From: Laura Gibbons <Laura.Gibbons@arun.gov.uk>
Sent: 07 September 2021 15:10
To: Planning.Responses <Planning.Responses@arun.gov.uk>
Cc: Simon Davis <Simon.Davis@arun.gov.uk>
Subject: RE: Planning Consultation on: P/119/21/DOC

Application No: P/119/21/DOC

Site Address: 253-255 Pagham Road Pagham PO21 3QB

Description of Works: Approval of details reserved by condition imposed under ref W/4001476 (P/58/19/PL) relating to Condition Nos 5 - Construction & Environmental Management Plan, 6 - surface water drainage, 7 - maintenance & management of surface water drainage and 14 - materials, finishes & detailing for external walls and roofs.

Drawing Title: **Proposed Drainage Arrangement
Sheet 1 of 2**

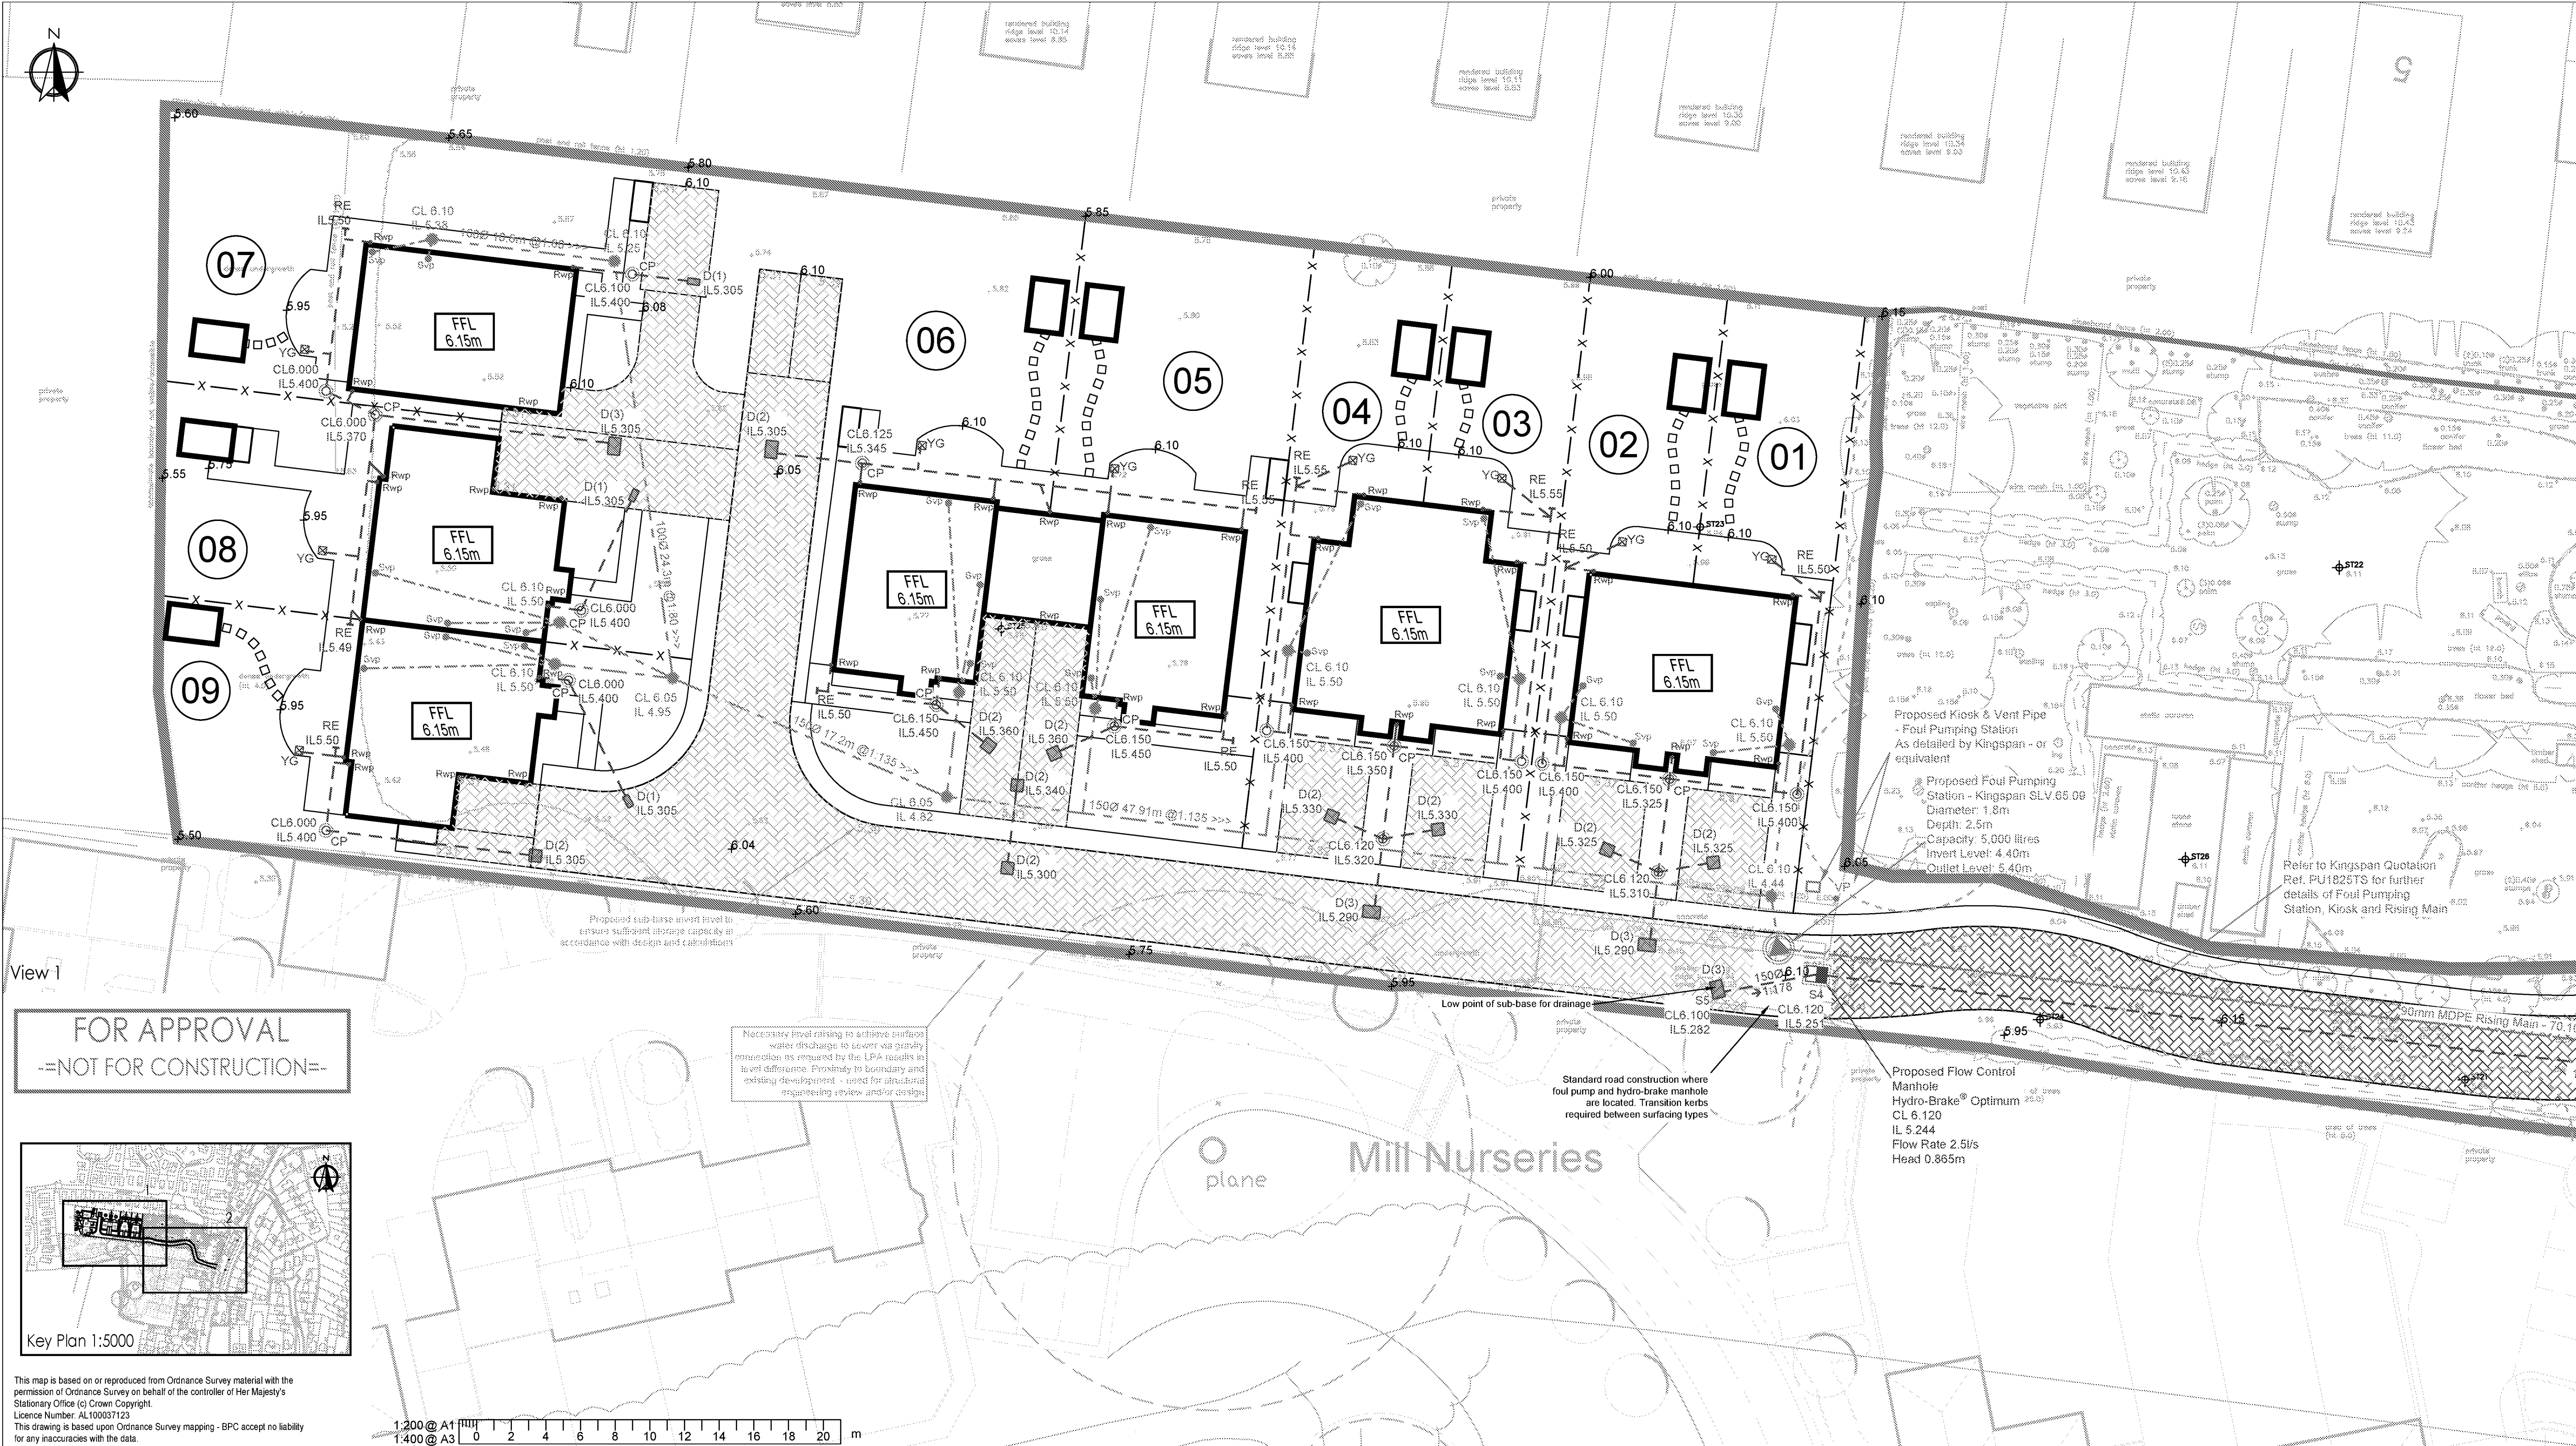
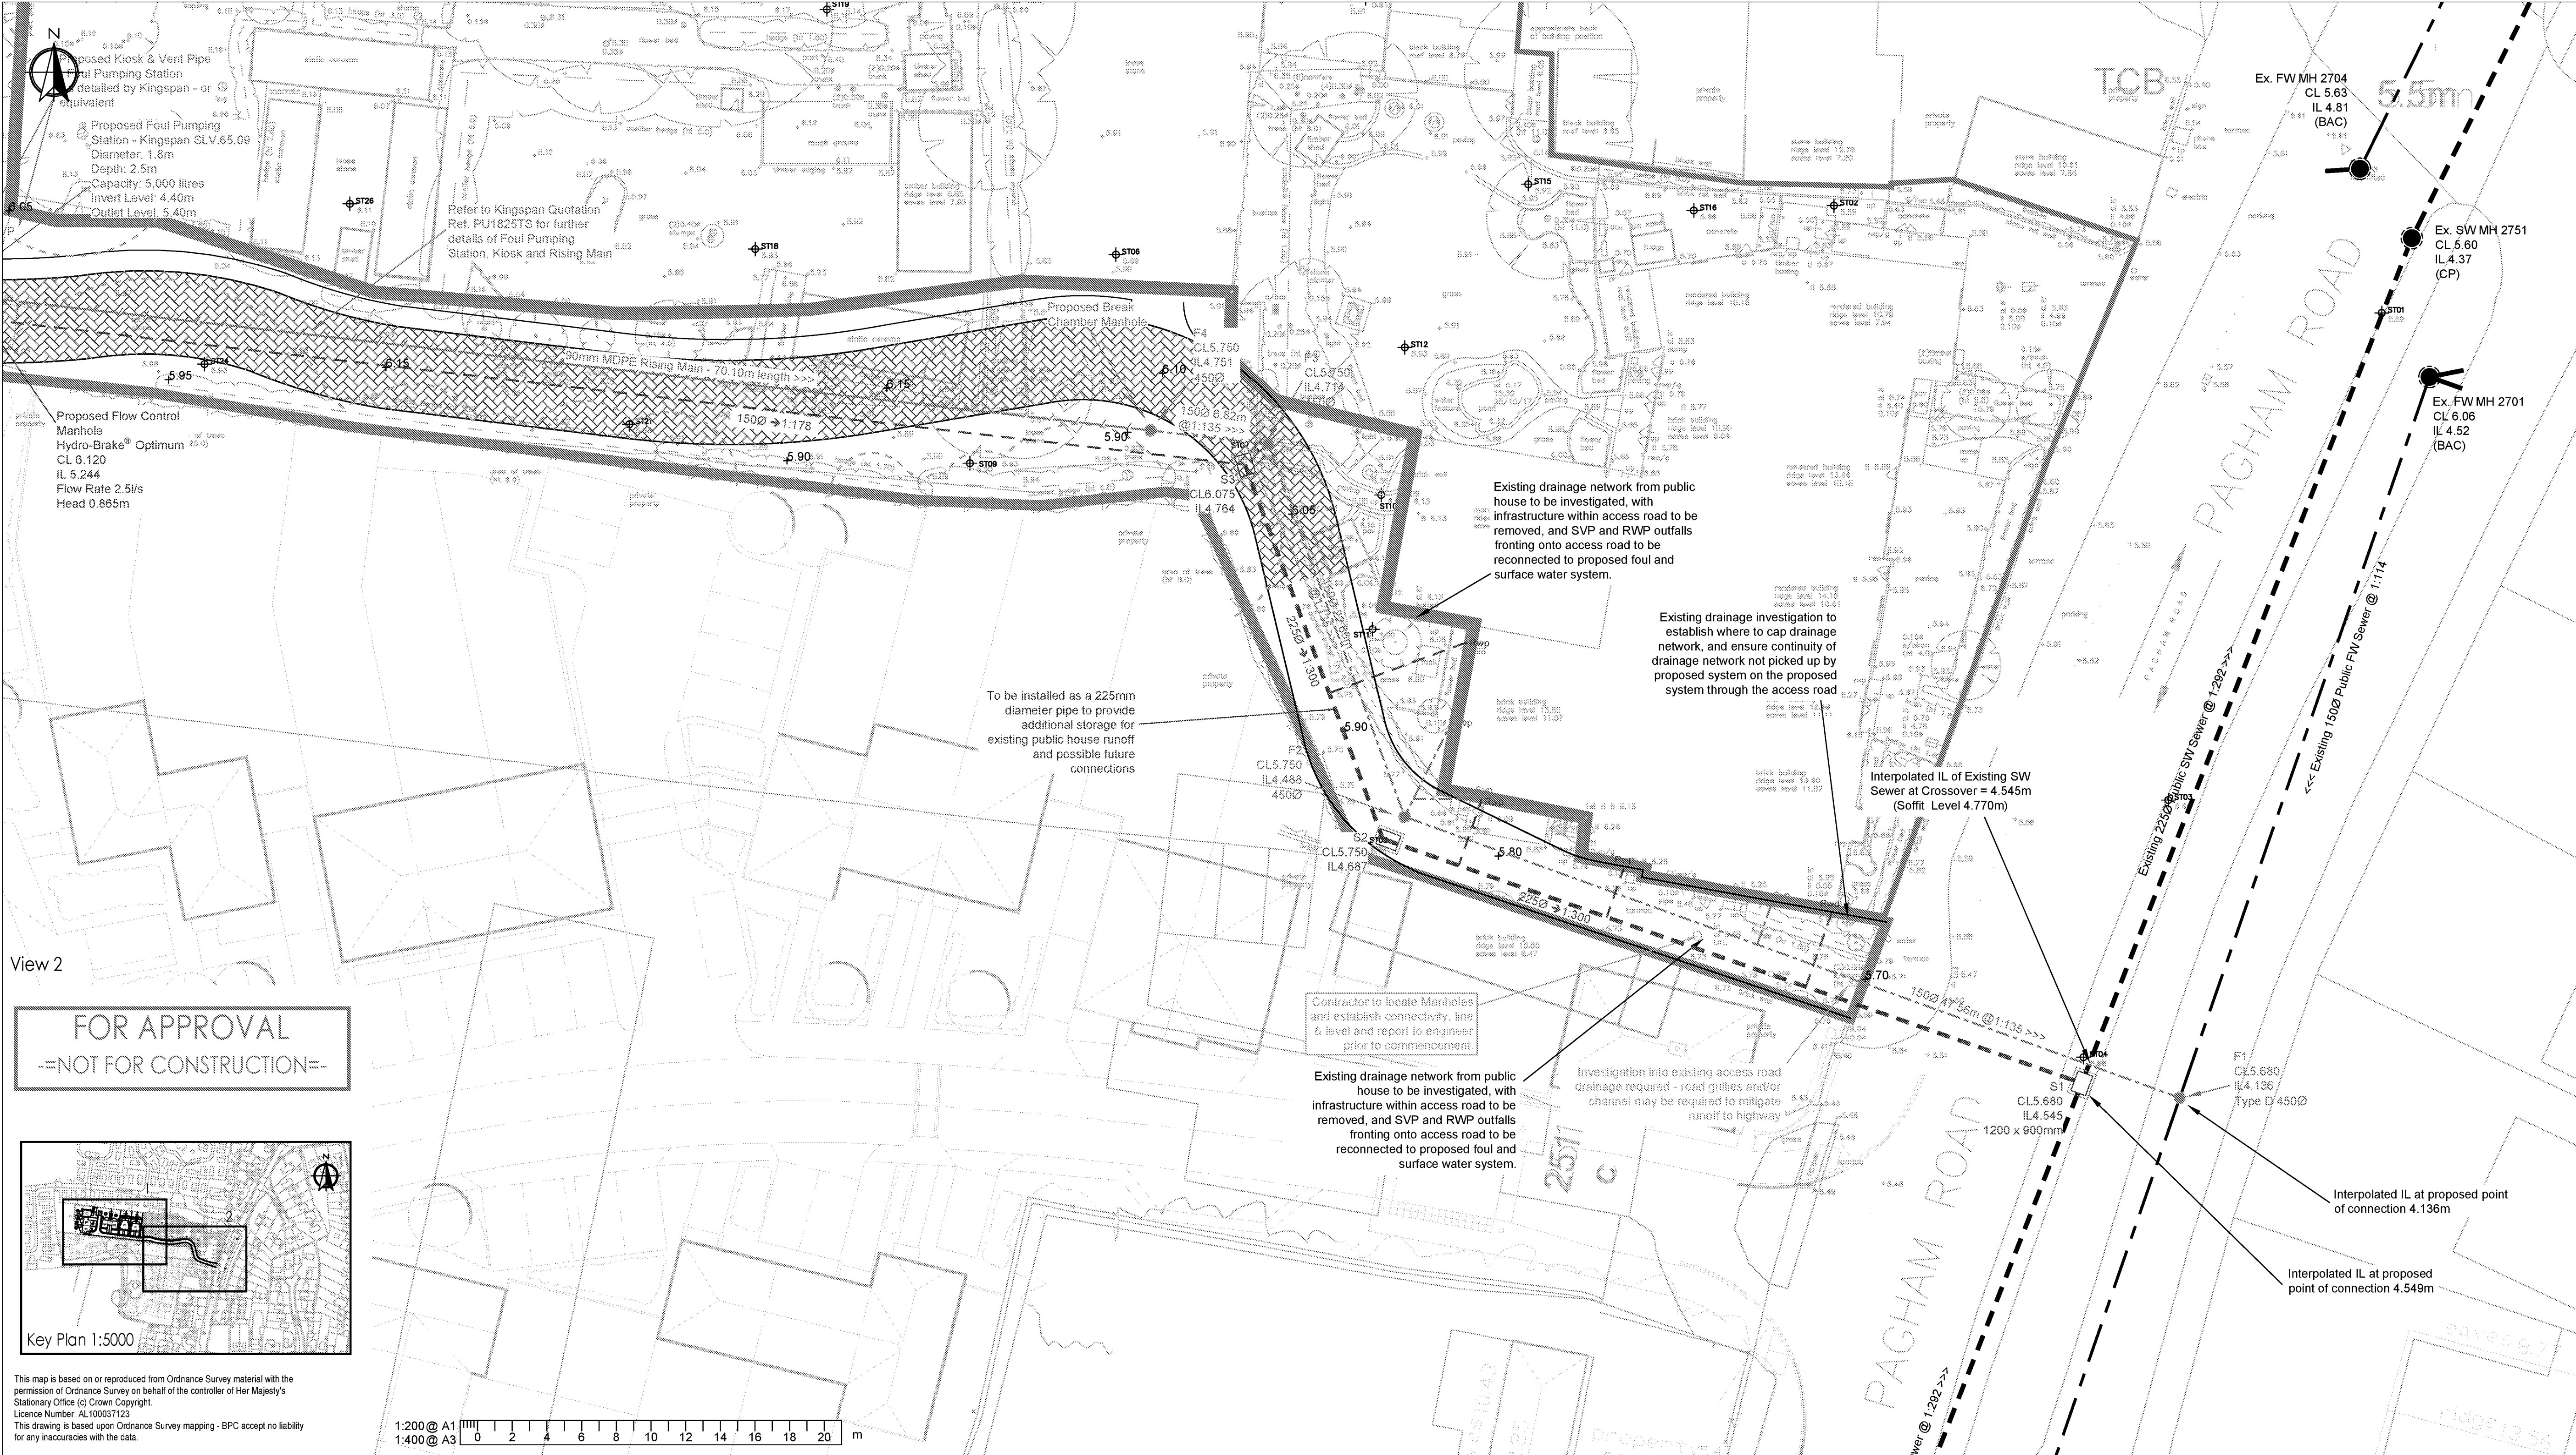
Please note the hydrobrake unit reference number on both plan and construction detail drawing. Please re-consult us once revised details are provided.
